CITY OF ALBUQUERQUE

February 14, 2019

**Re: Cinnamon Morning - 2700 Rio Grande Blvd NW
Grading and Drainage Plan and Drainage Report
Engineer's Stamp dated: 1/16/2019 (G12D024)**

GRADING AND DRAINAGE PLAN

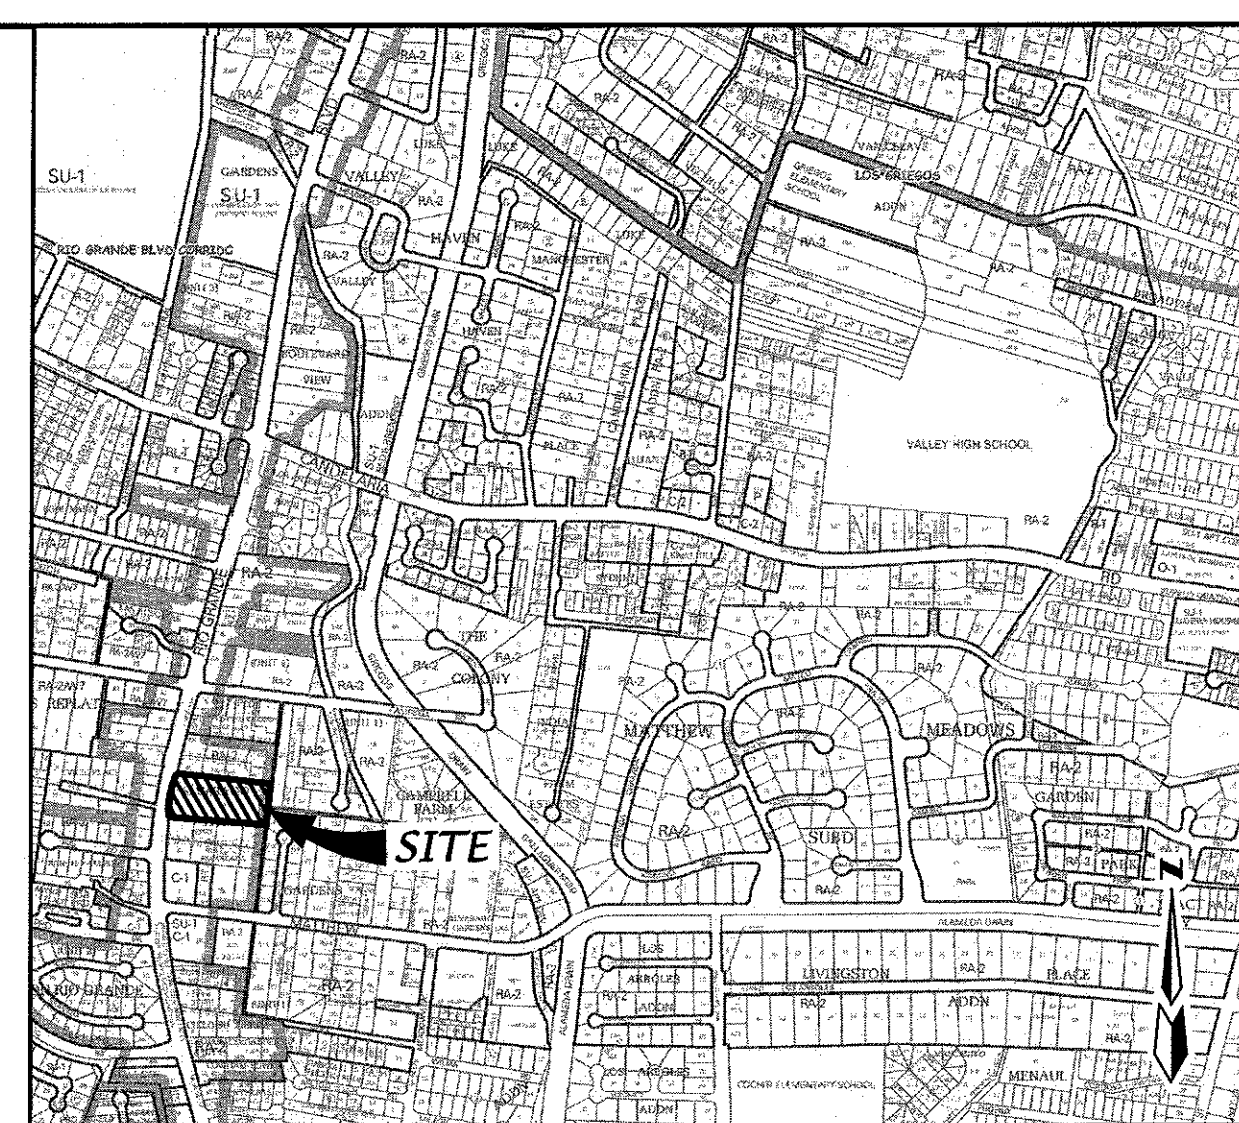
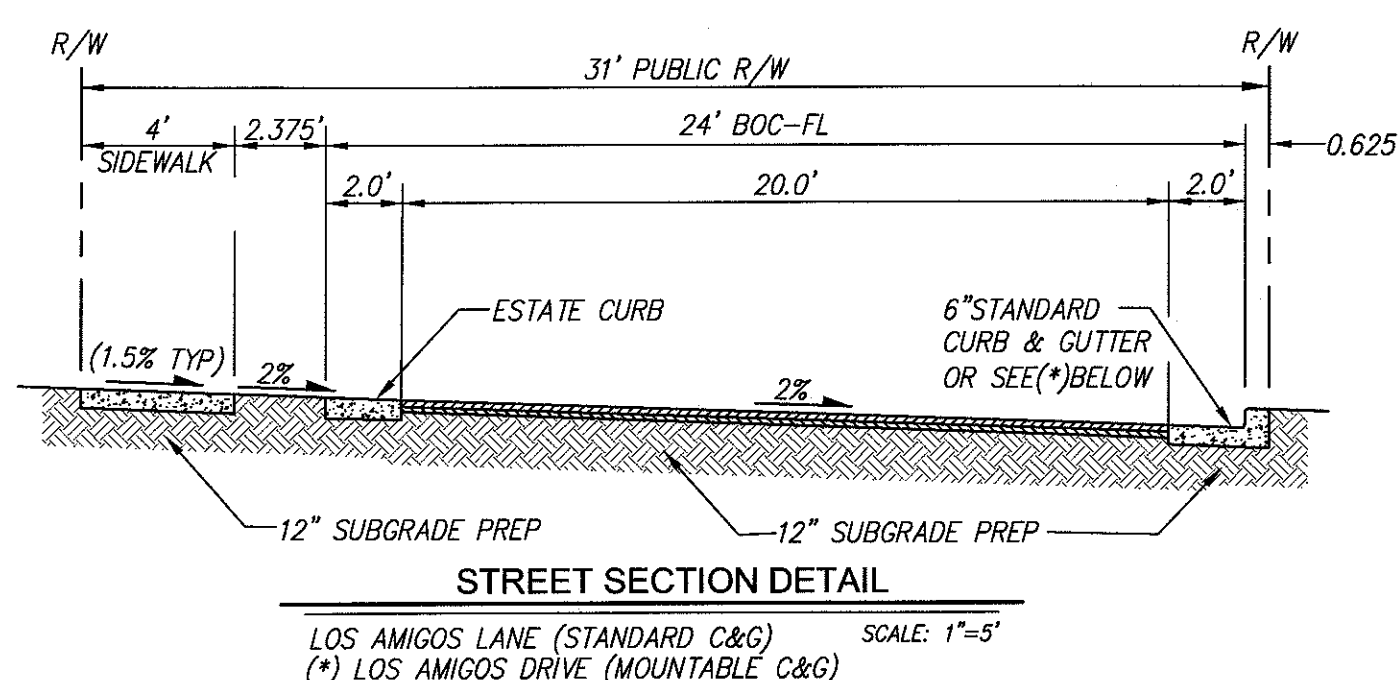
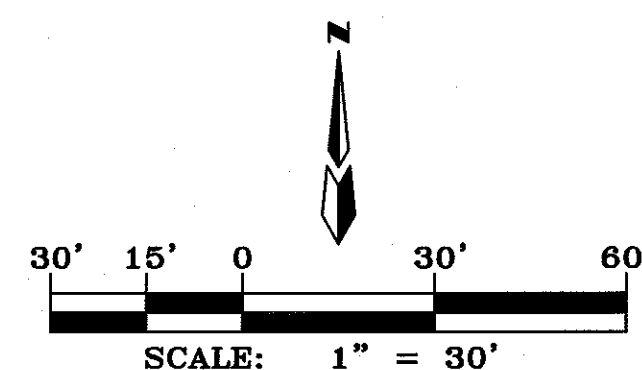
A Flat Grading Scheme, per DPM 22.5.G, is proposed which must include a block wall around the perimeter and onsite retention of the 100 year 10 day volume.

1. A block wall must be shown and labeled on both the G&D Plan and the Site Plan. Include a typical cross-section of the wall showing the proximity to the property line and the existing and proposed grades.
2. Existing spot elevations must be added on the adjacent property at each of the lot corners.
3. The hatch pattern at the edge of the pond must be identified and added to the legend.

4. The emergency spillway appears to be through Los Amigos Drive into Rio Grande Blvd. and should be sized for the peak 100 year inflow into the pond. Weir depth calculations are required on the G&D Plan to identify the emergency overflow elevation which must be lower than the Top of Pond.
